DEVELOPMENT REVIEW BOARD
SUPPLEMENTAL SUBMITTAL

PROJECT NO. PR-2020-004747

Application No. SI-2021-00484

DESCRIPTION: Revised site plan & detail sheet, revised building elevations with response letter, revised landscape plan,

MARK	DATE	DESCRIPTION
ISSUE DATE:	---/---/---	
PROJECT NO:	221029	
CAD FILE:		
DRAWN BY:	EP	
CHKD BY:	SE	
COPYRIGHT:	S-E-A STUDIOS, P.C.	
SHEET CONTENT:	EXTERIOR ELEVATIONS

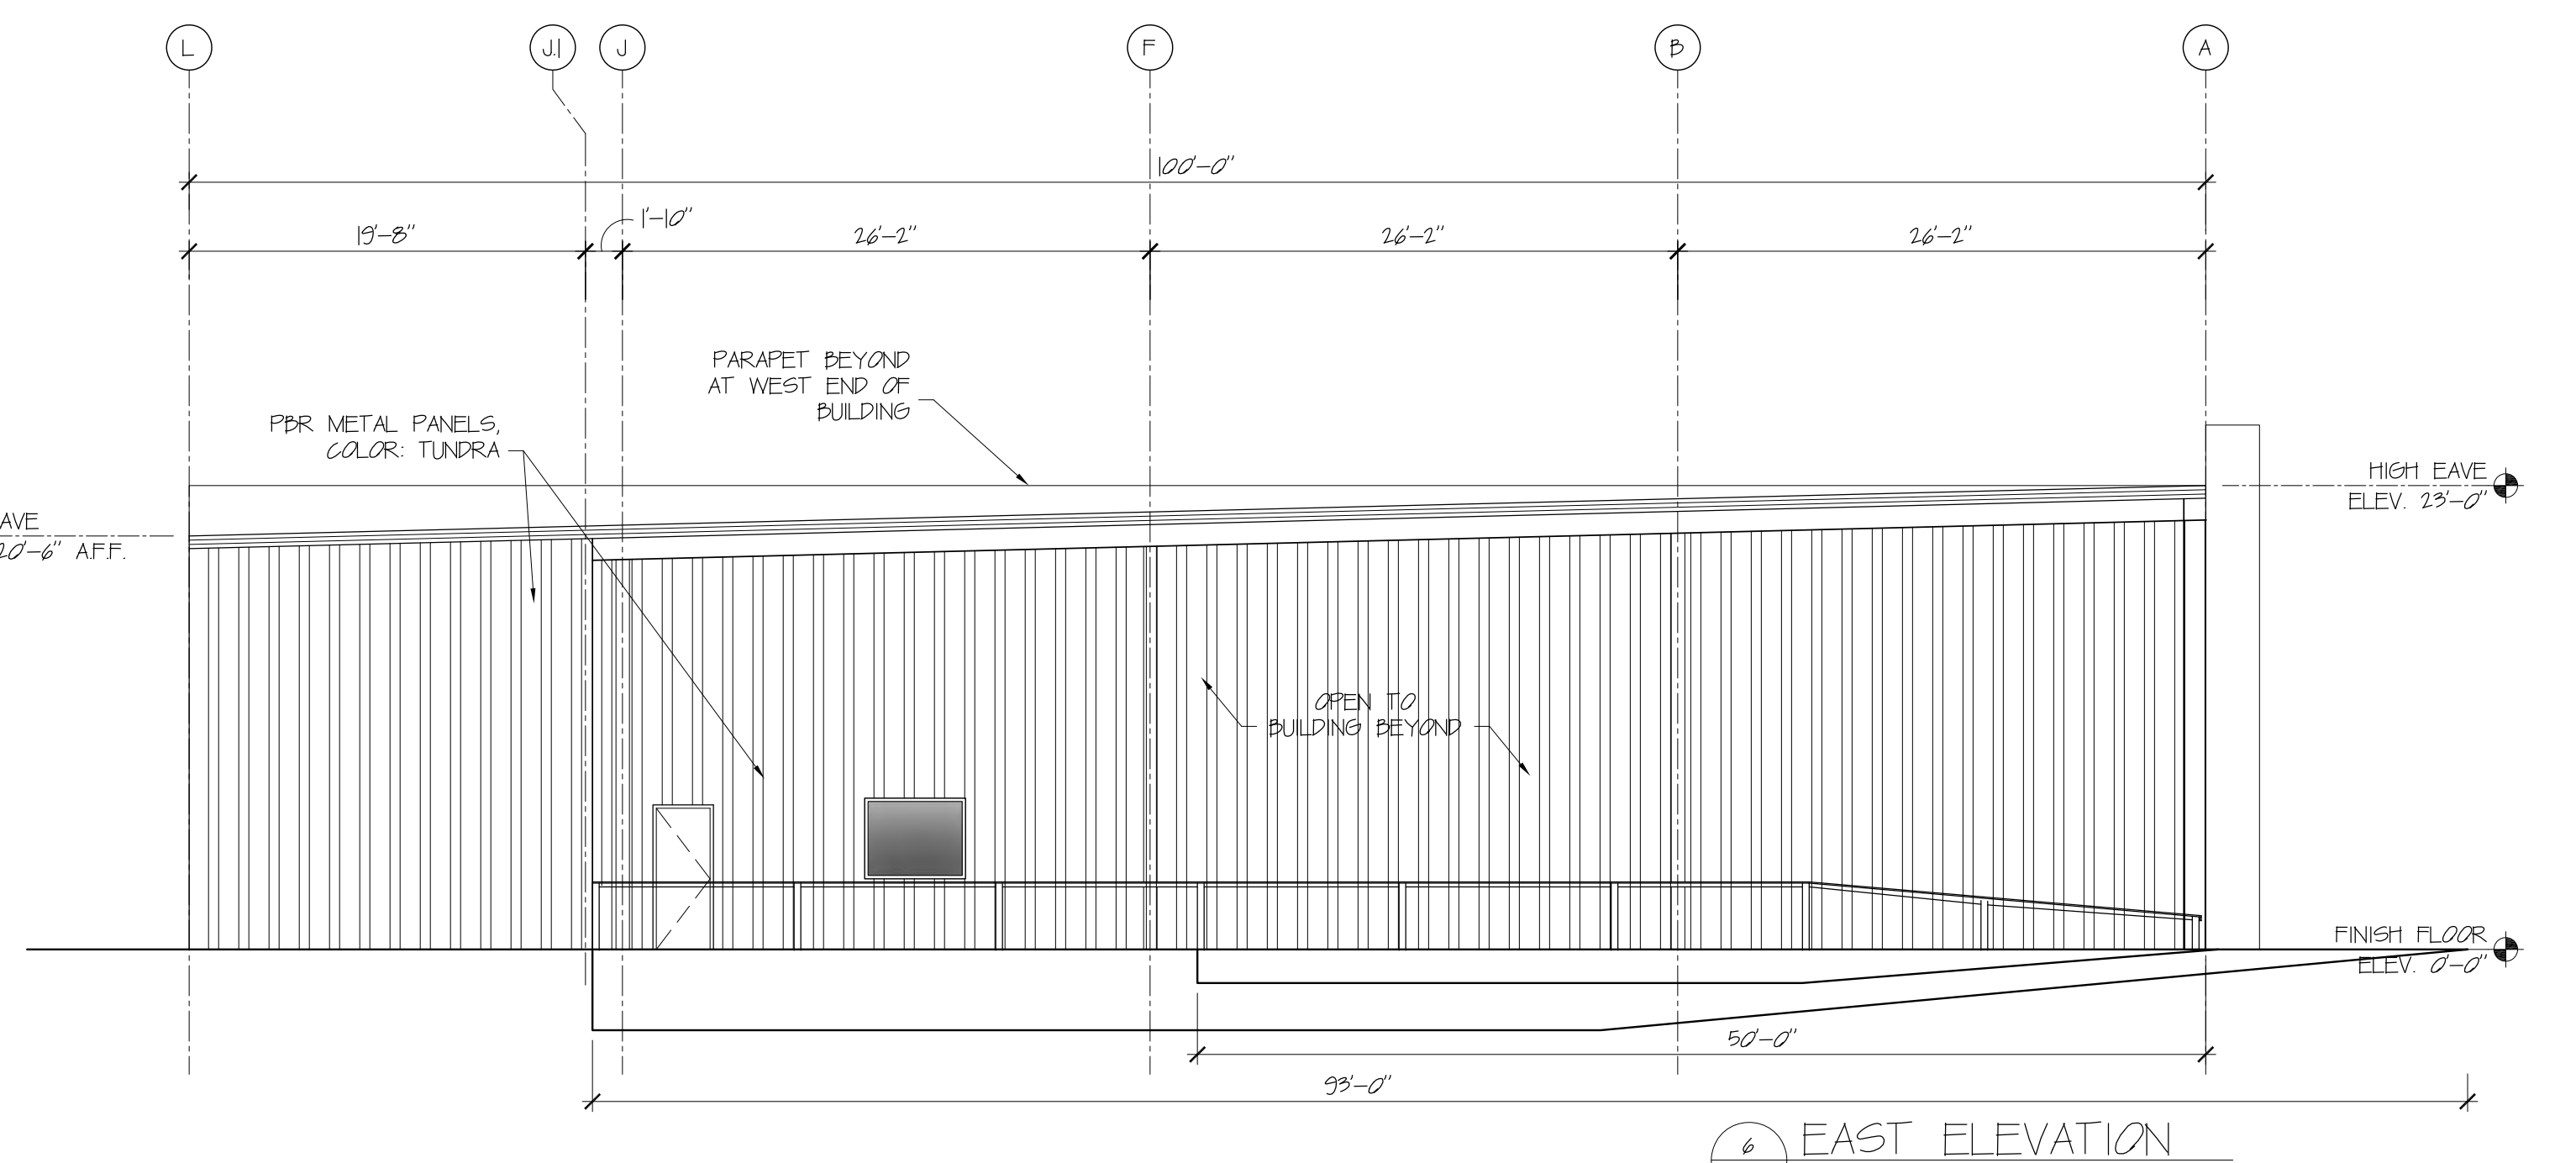
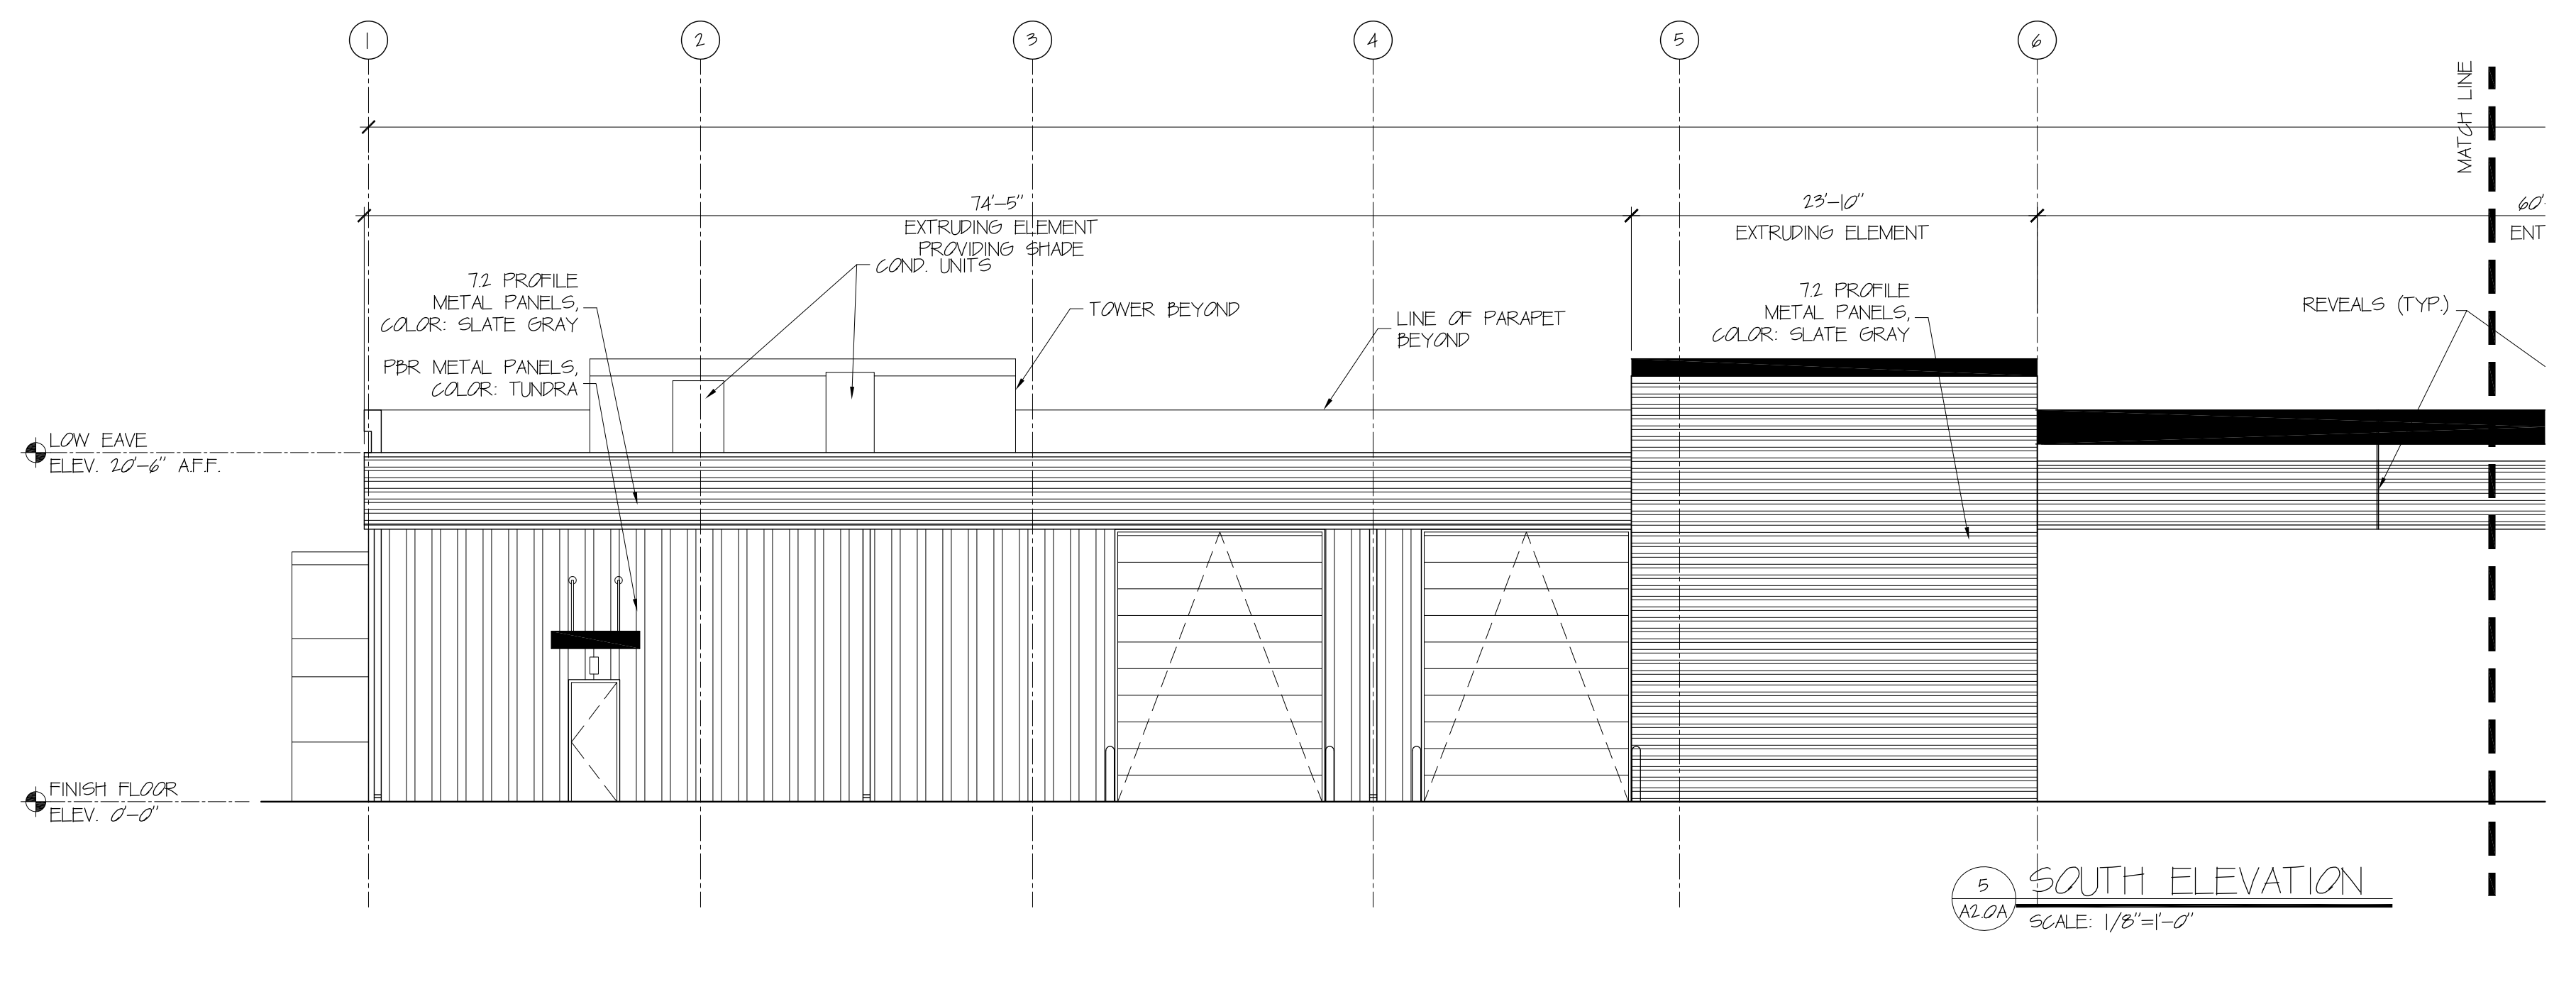
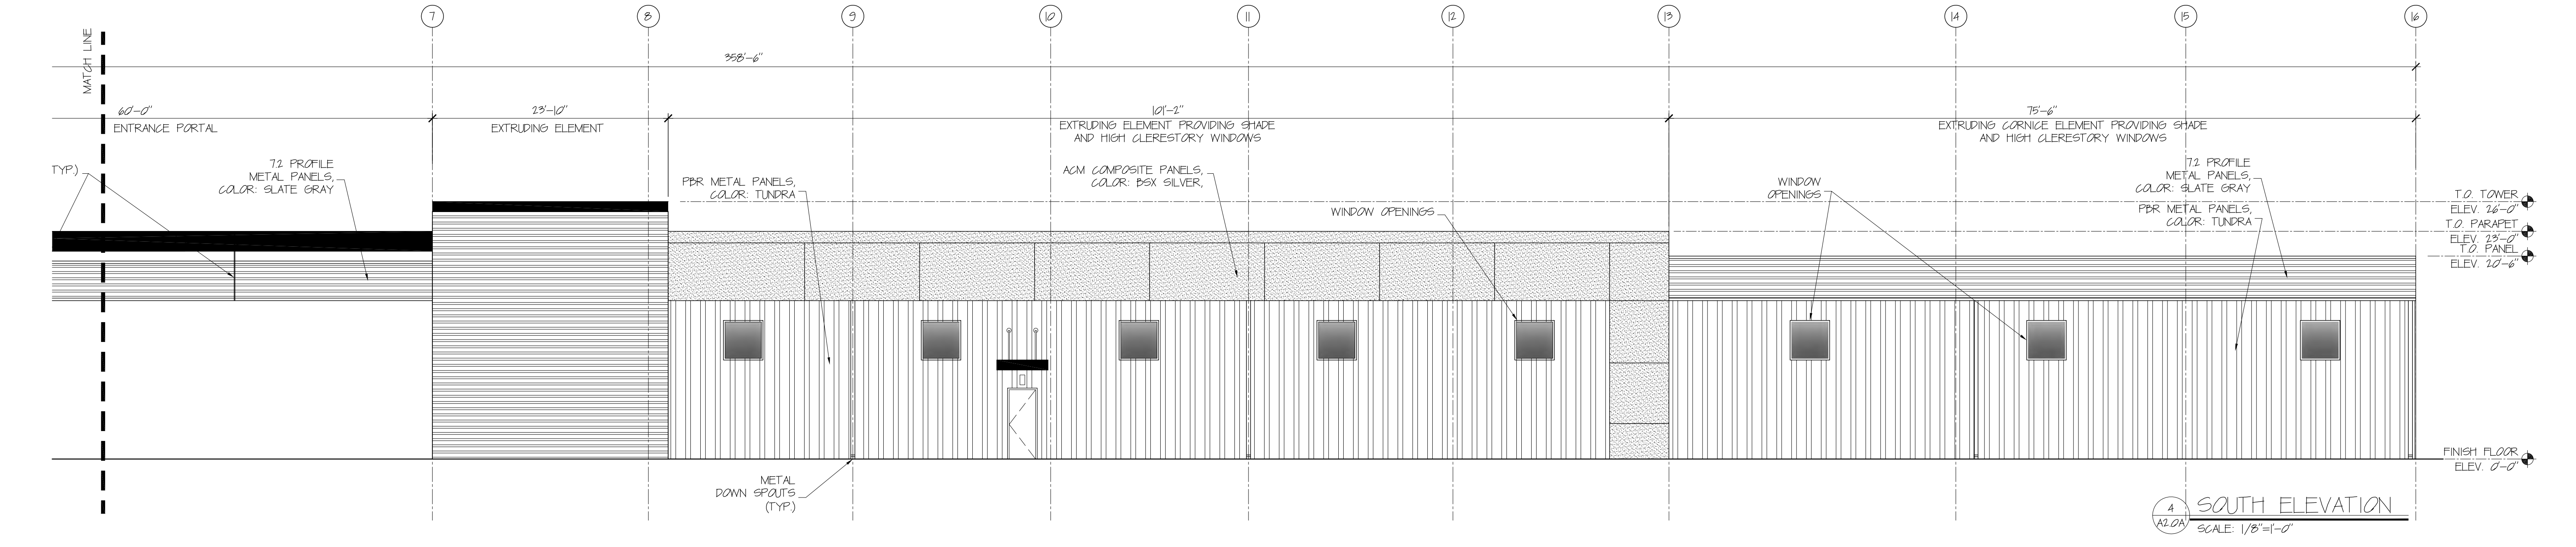
Elevation Review Comments:

The elevation needs to meet the following requirements:

1. Façades shall be designed to provide a sense of human scale at ground level by providing a clear architectural distinction between ground floor levels and all additional levels.

2. Each street-facing façade shall incorporate at least 2 of the following features along at least 30 percent of the length of the façade, distributed along the façade so that at least 1 of the incorporated features occurs every 40 feet.

3. Each street facing façade longer than 100 feet shall incorporate at least 1 of the following additional features.

Response for requirement #2:

The North façade:

incorporates ground floor windows, primary entrance, high clerestory windows, portals, canopies and extruded wall elements providing shade. The total length of the façade is 358 feet and 9 inches. 30 Percent of the façade is 108 feet.

2d) Entrance portals, canopies and extruding elements providing shade have been placed along a total of 310 feet along the façade length. See elevation. Arcades, trellises and awnings not provided.

The South façade:

incorporates extruding elements, an entrance portal and high clerestory windows. The total length of the façade is 358 feet and 9 inches. 30 Percent of the façade is 108 feet.

2d) Entrance portals, canopies and extruding elements providing shade have been placed along a total of 310 feet along length of façade.

The North façade:

3a) Wall plane projections or recesses of at least 1 foot in depth at least every 100 feet of façade length provided.

3e) Change in parapet height every 100 feet of façade length provided.

See North elevation for change in parapet height every 100 feet.

3e) Change in parapet height every 100 feet of façade length provided.

See South elevations for change in parapet height every 100 feet.
